Please ask for: Nicola Moore  
Email: [nicola.moore@arun.gov.uk](mailto:nicola.moore@arun.gov.uk)  
Telephone: Ext 37944  
Our Ref: BR/122/20/OUT  
Your Ref:  
Date: 8th July 2020

**Application for Outline Planning Permission**

**Development:** demolition of garth house and west view to be replaced with 20 self contained apartments  
**Location:** Garth House High Street Bognor Regis PO21 1HQ

1:200 1:1250

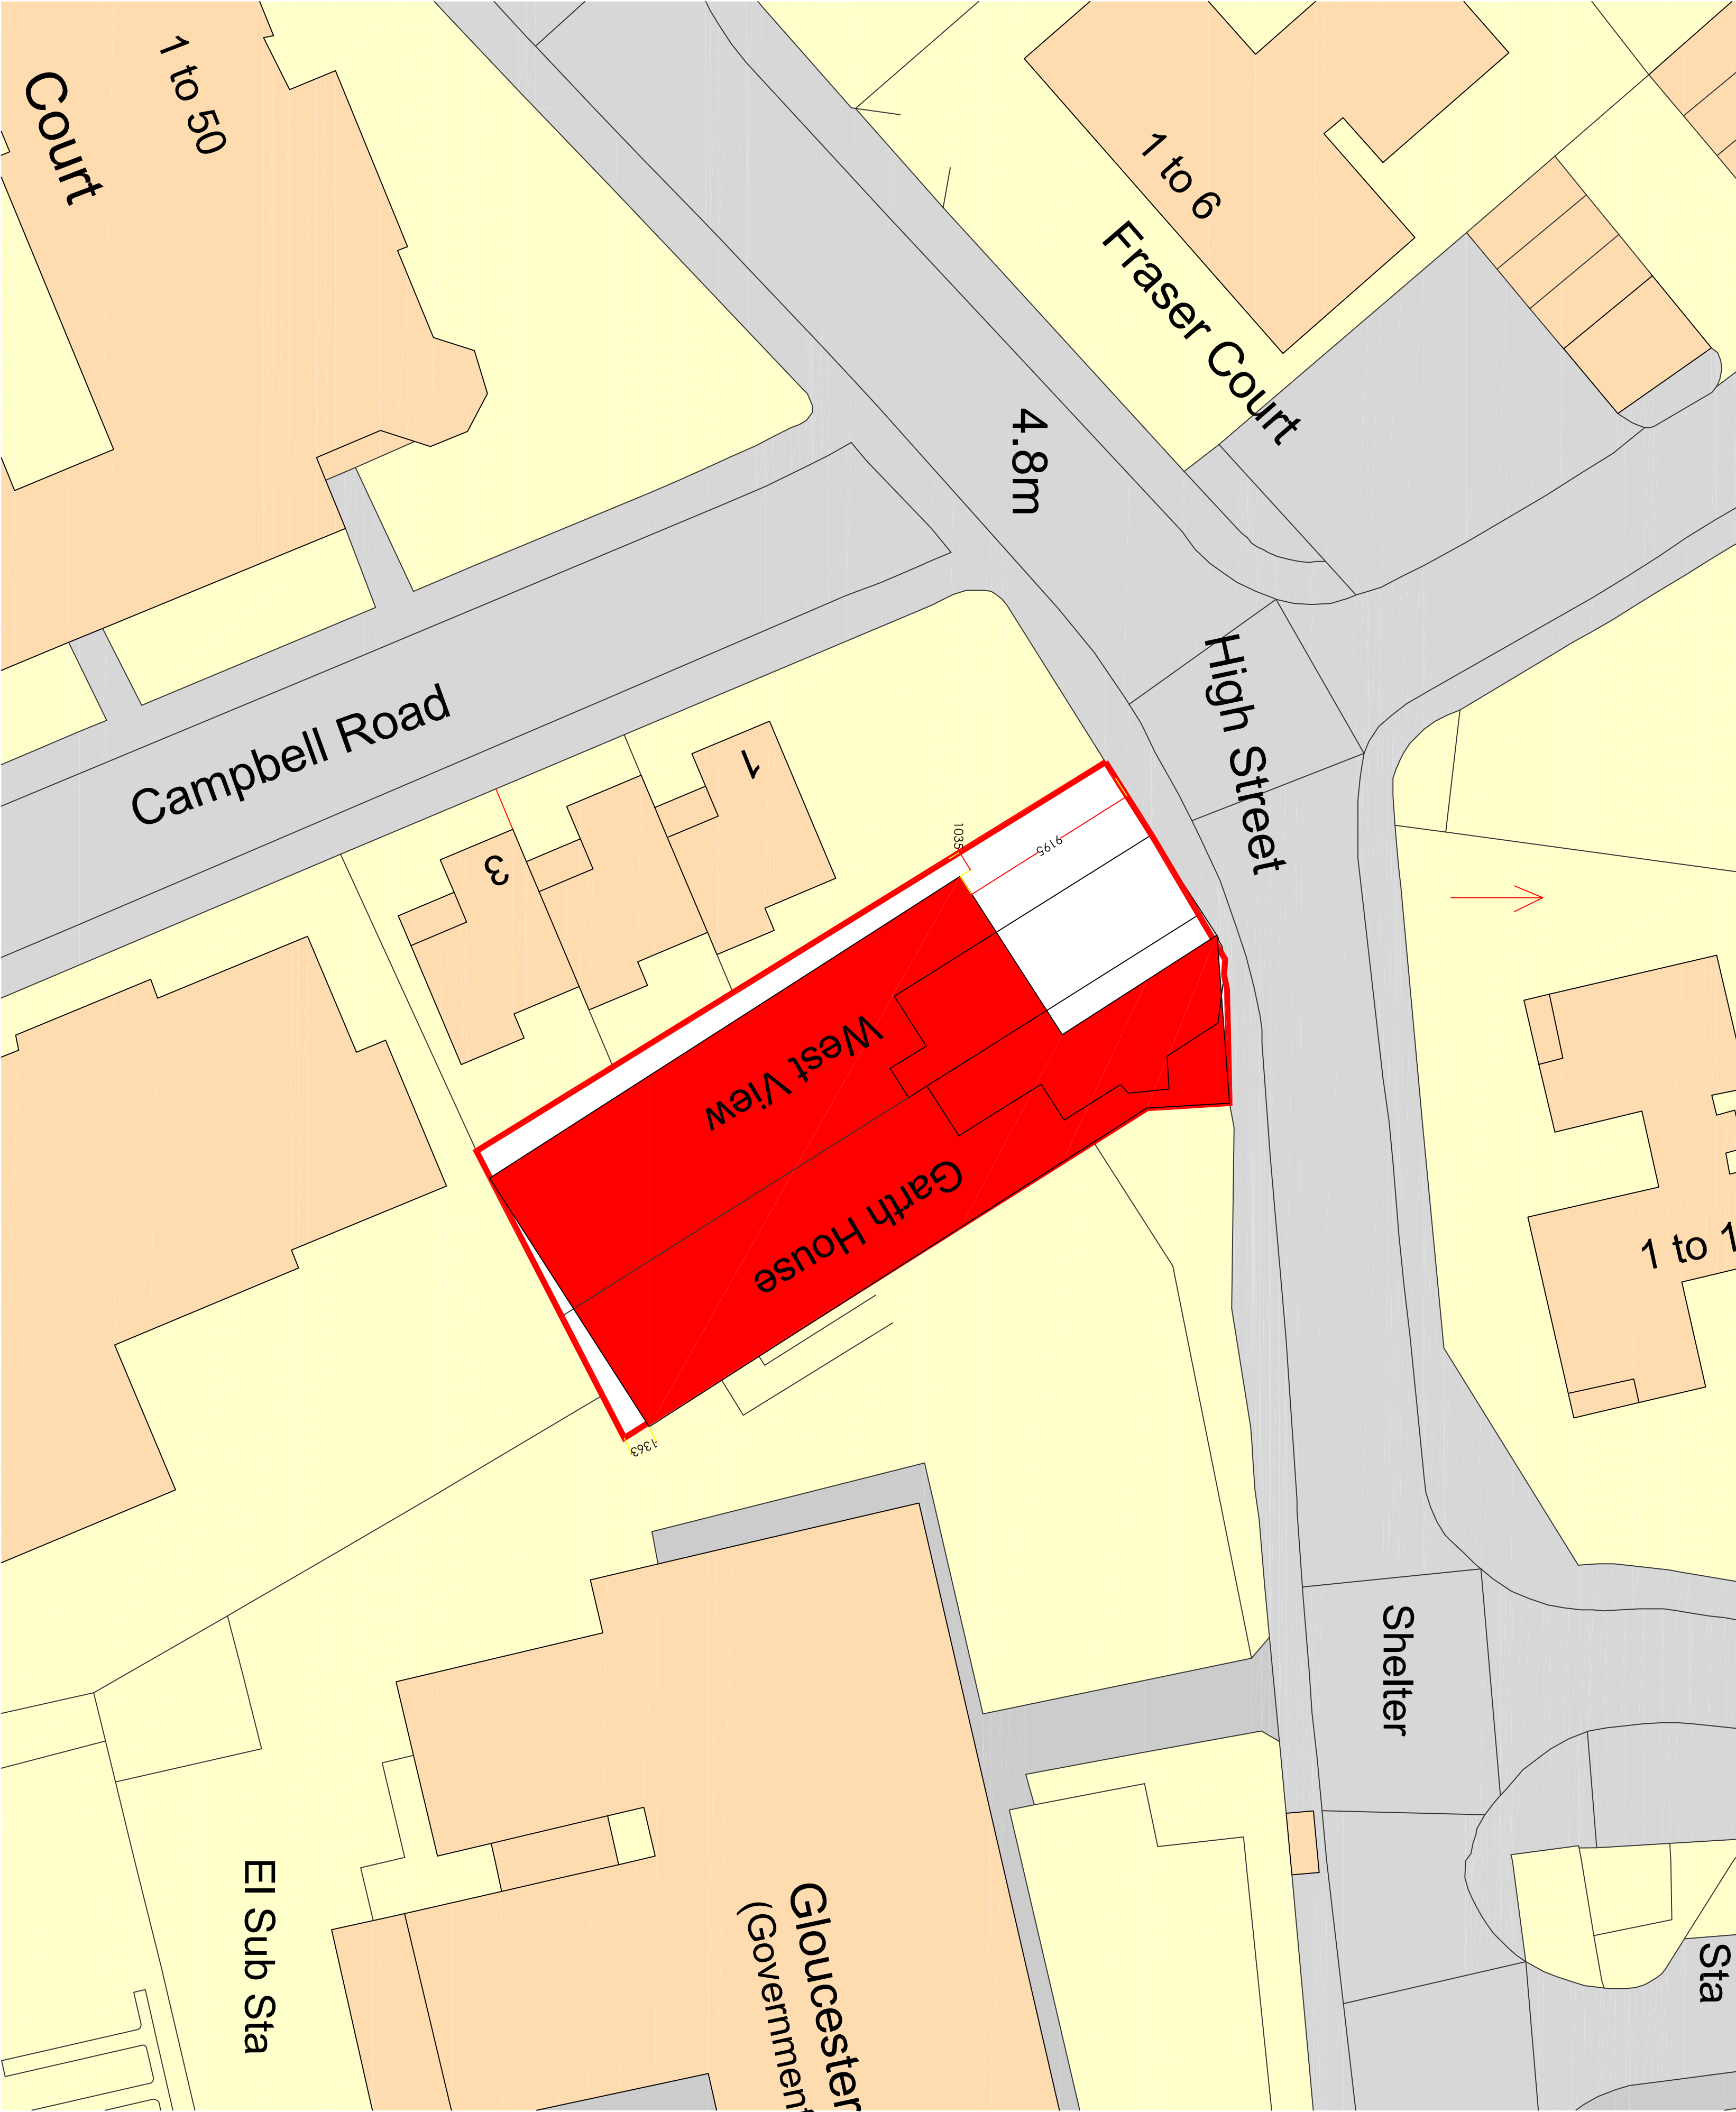
Please amend the Location Plan to include road names and show the direction of North. Also remove any red edges that are not applicable to the application site. Please re submit at a scale of 1:1250 or 1:2500

Please amend the Block Plan to show the direction of North and remove red edges that are not applicable to the application site. The Block plan should also include the footprint of the demolished building/s and all measurements to boundaries of the proposed development. Please submit at a scale of 1:500 or 1:200
